Sage and Unser Marketplace

Supplemental Calculations

Engineer's Stamp Date 11/20/2012 (M10/D019)

Re: Sage & Unser Marketplace Master Drainage Plan Engineer's Stamp dated 10/18/10 (M10/D019)

ROLLING HILLS SUBDIVISION UNIT THREE

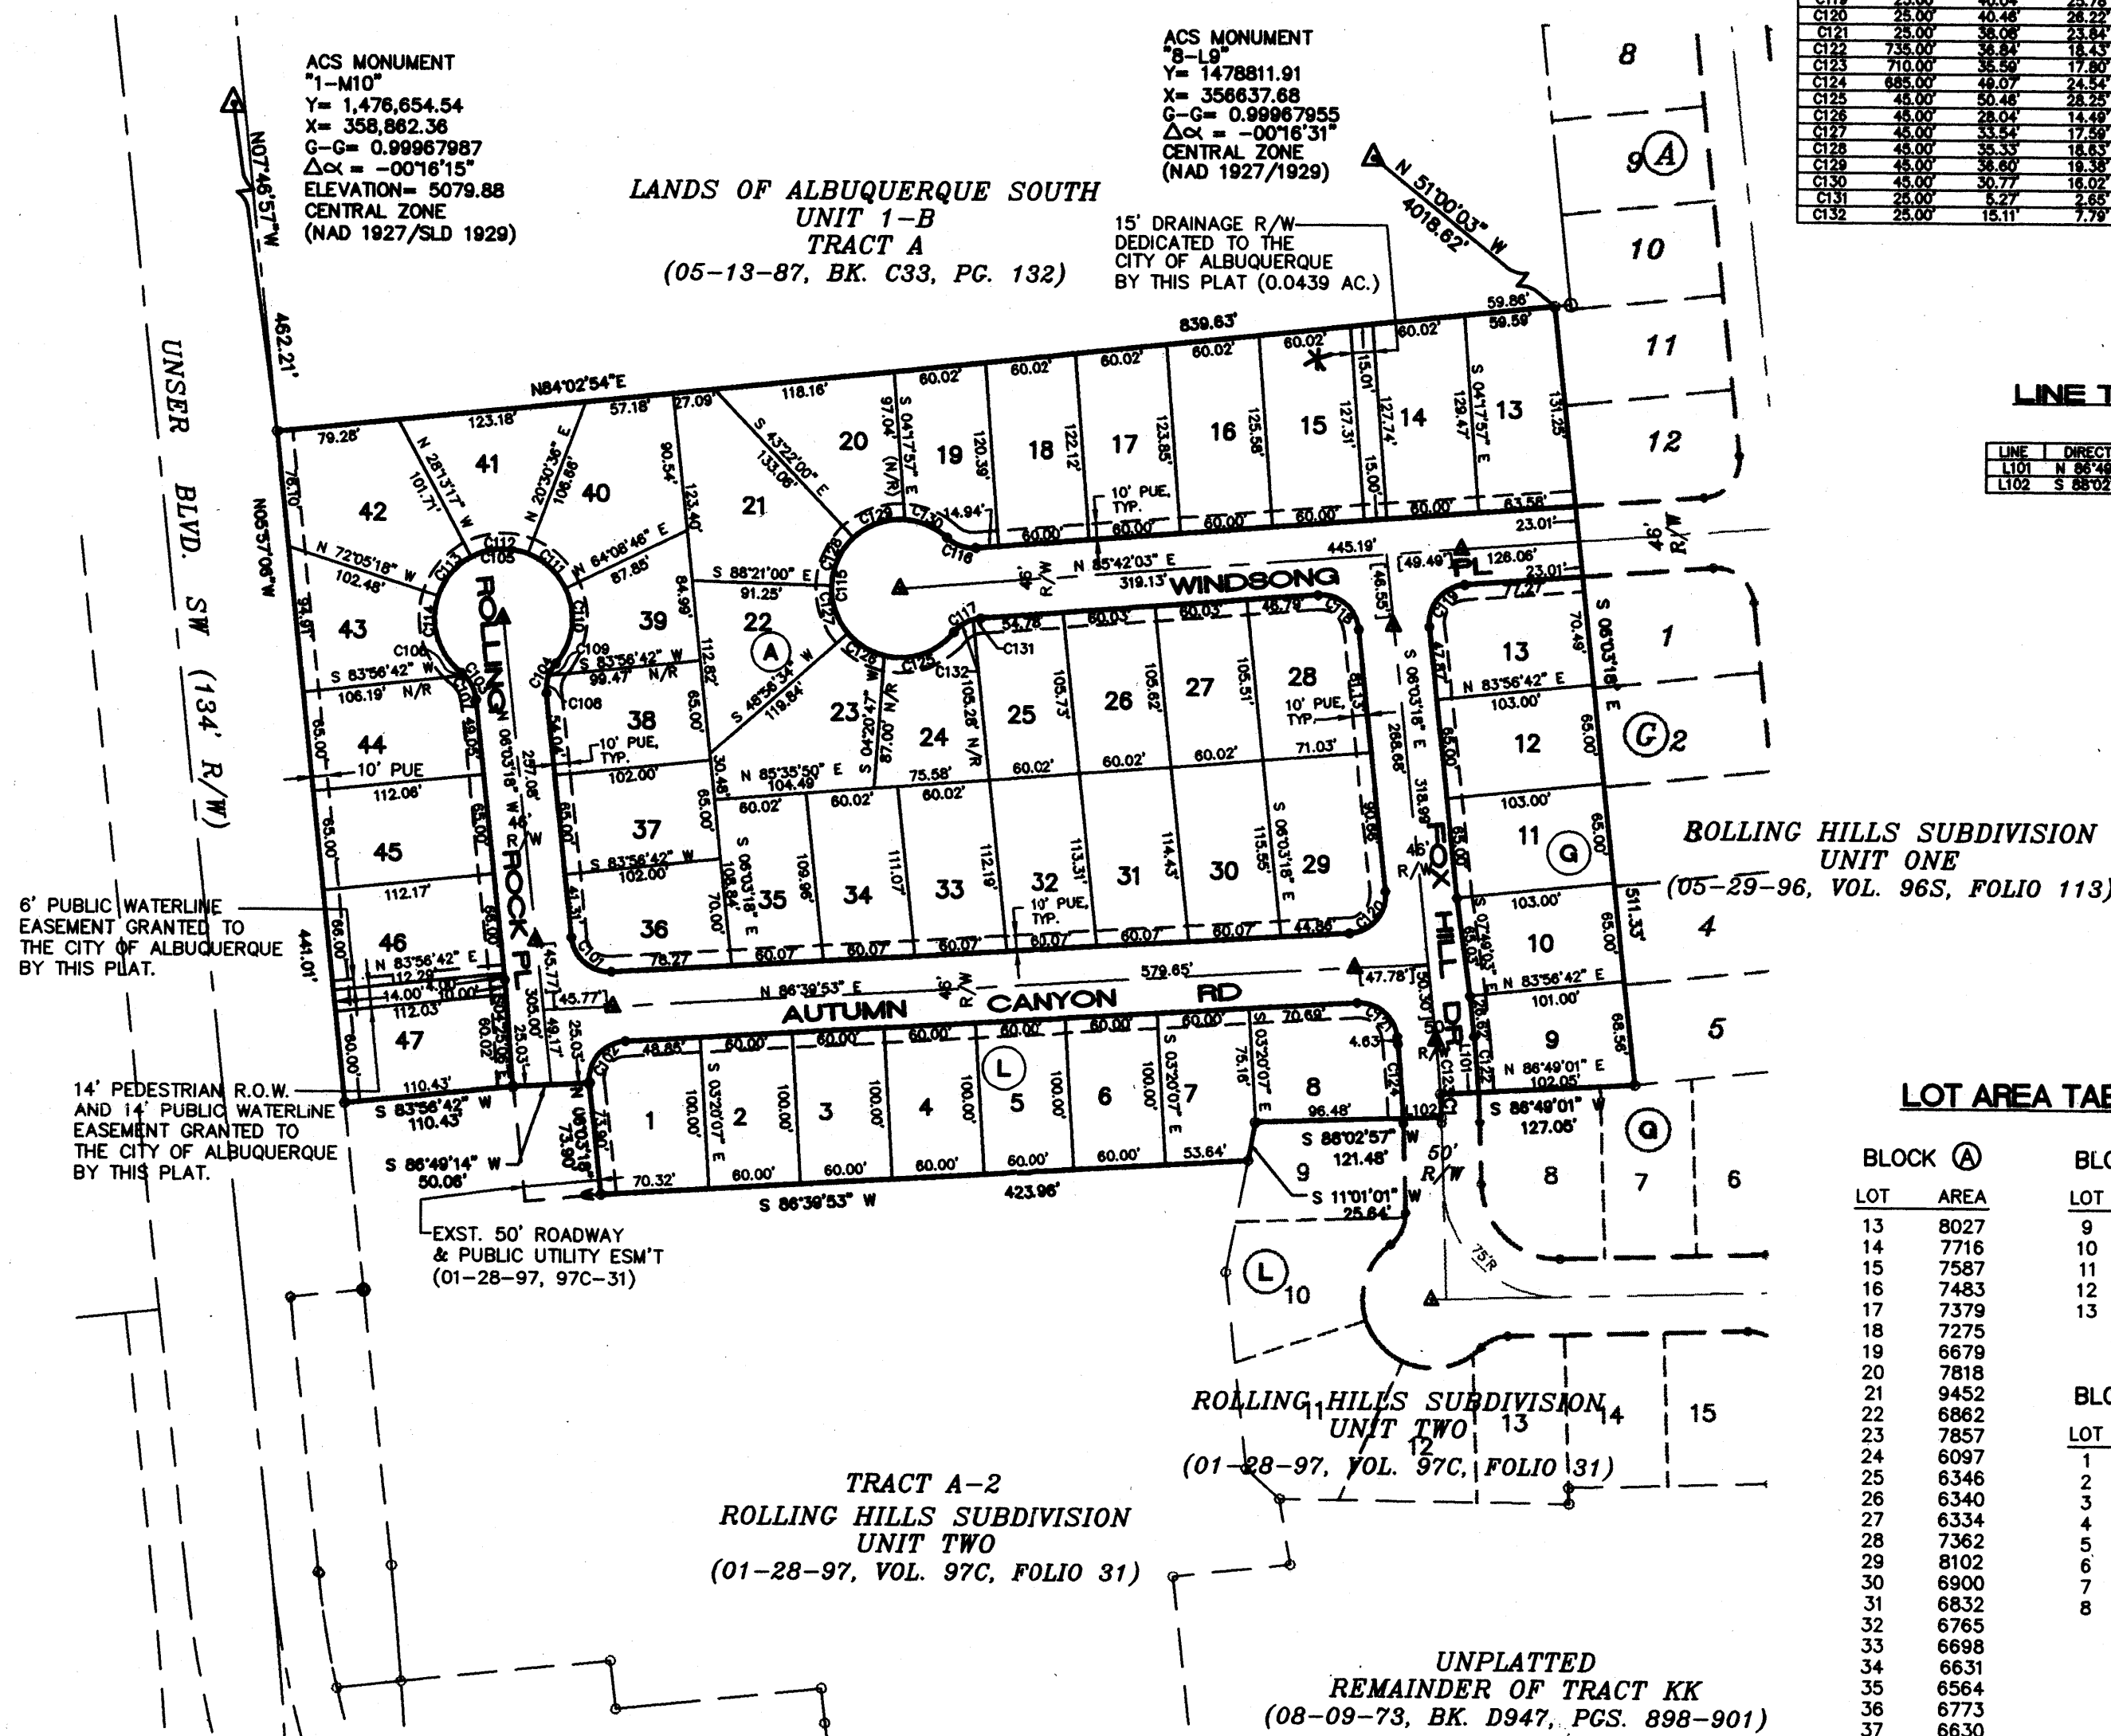
How and why is a discharge of 19.9 cfs allowed to leave the site via an easement? What does this easement consist of? Please verify that this easement is still maintained and operable.

BASIN 2 consisting of the remaining portions of the site tracts is permitted a to free discharge 19.9 cfs to the existing public 15' wide Drainage R.O.W. dedicated to the City of Albuquerque by the Plat for Rolling Hills Subdivision, Unit Three, dated March 1997 (see attached copy of plat) located near the southeast portion of PROPERTY. The overall basin will consist of the following Tract portions:

- 3. An On-site Basin Map has been added with associated Basin Calculations.
- 4. Individual tract areas have been reviewed and corrected.
- 5. The entirety of Tract A is 9.1 acres. Based on the Rolling Hills Subdivision Unit 3 Master Drainage Plan dated January 19, 1996, Tract A was identified as an off-site adjacent property. The 'dashed' diagonal line shown through Tract A is a basin line which divided the property into two triangular areas. The northwest triangle was to discharge to Sage Road and the southeast triangle was to discharge 19.9 cfs through the public 15' wide Drainage R.O.W. dedicated to the City of Albuquerque by the Plat for Rolling Hills Subdivision, Unit Three, dated March 1997 (see attached copy of plat) located near the southeast portion of PROPERTY..

PRELIMINARY
PLAT FOR
**SAGE AND UNSER
MARKETPLACE**
BEING A REPLAT OF
TRACT A
LANDS OF ALBUQUERQUE SOUTH, UNIT 1-B
WITH THE TOWN OF ATRISCO GRANT
CITY OF ALBUQUERQUE
BERNALILLO COUNTY, NEW MEXICO
AUGUST 2010

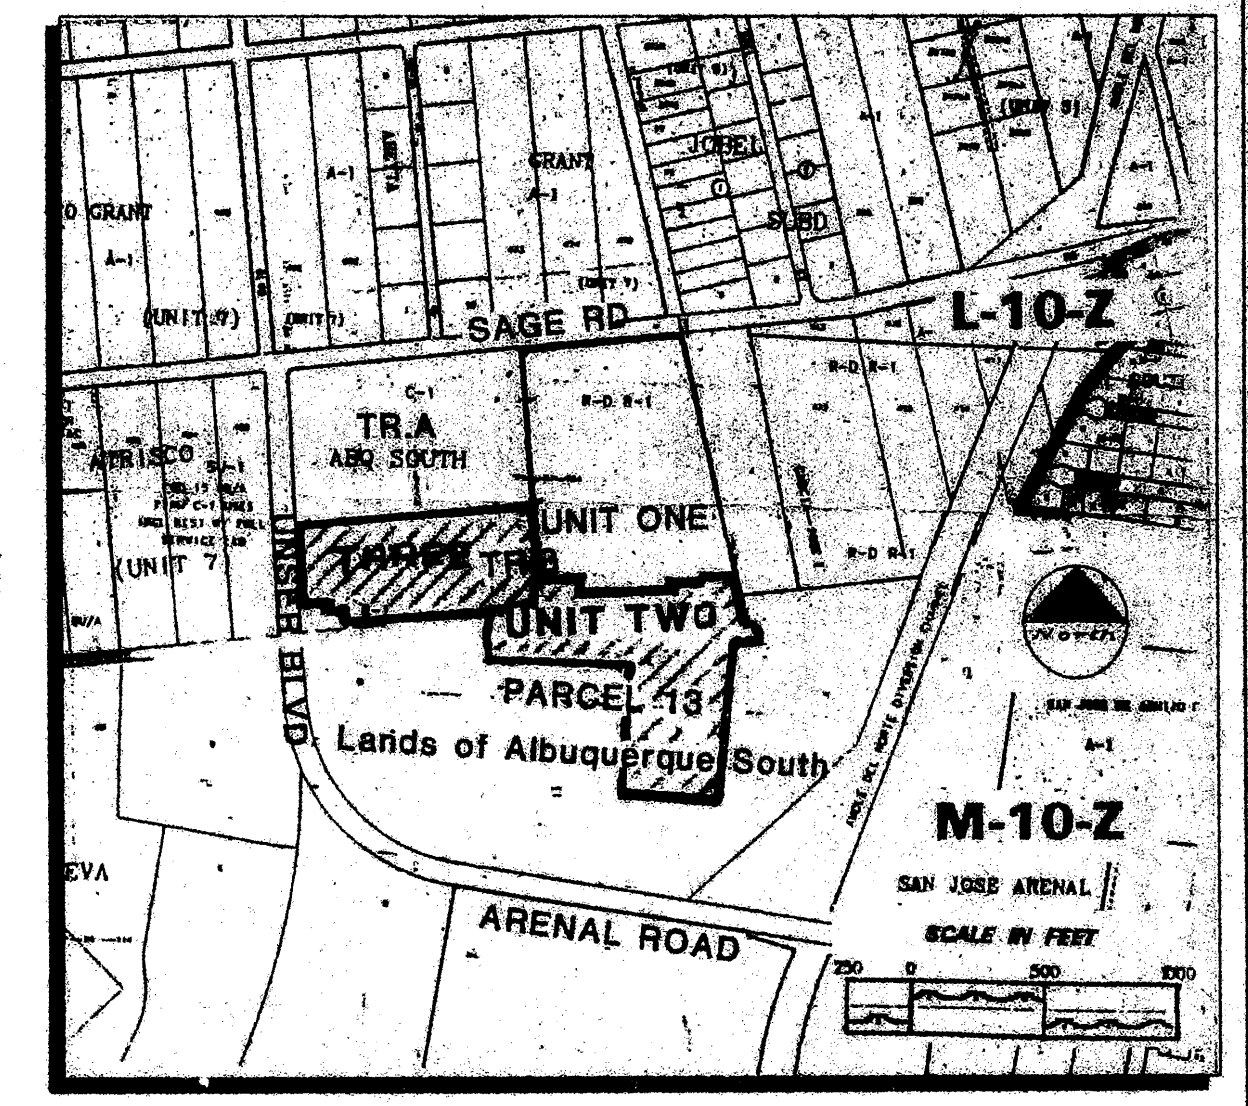
The Preliminary Plat showing Tracts A-1 through A-5 is missing.

Is Tract A 9.55 acres or is this the Sub-Basin at 4.78 acres? What is the dashed Unser Outpursers.

The Tracts and their areas are different from one page to the other.

- 1. Preliminary Plan showing Tracts A-1 through A-5 is included.
- 2. The storm drain in Sage Road has been constructed as part of the Unser Blvd. SW Improvements. Copies of the as-built plans were provided for your files under separate cover.
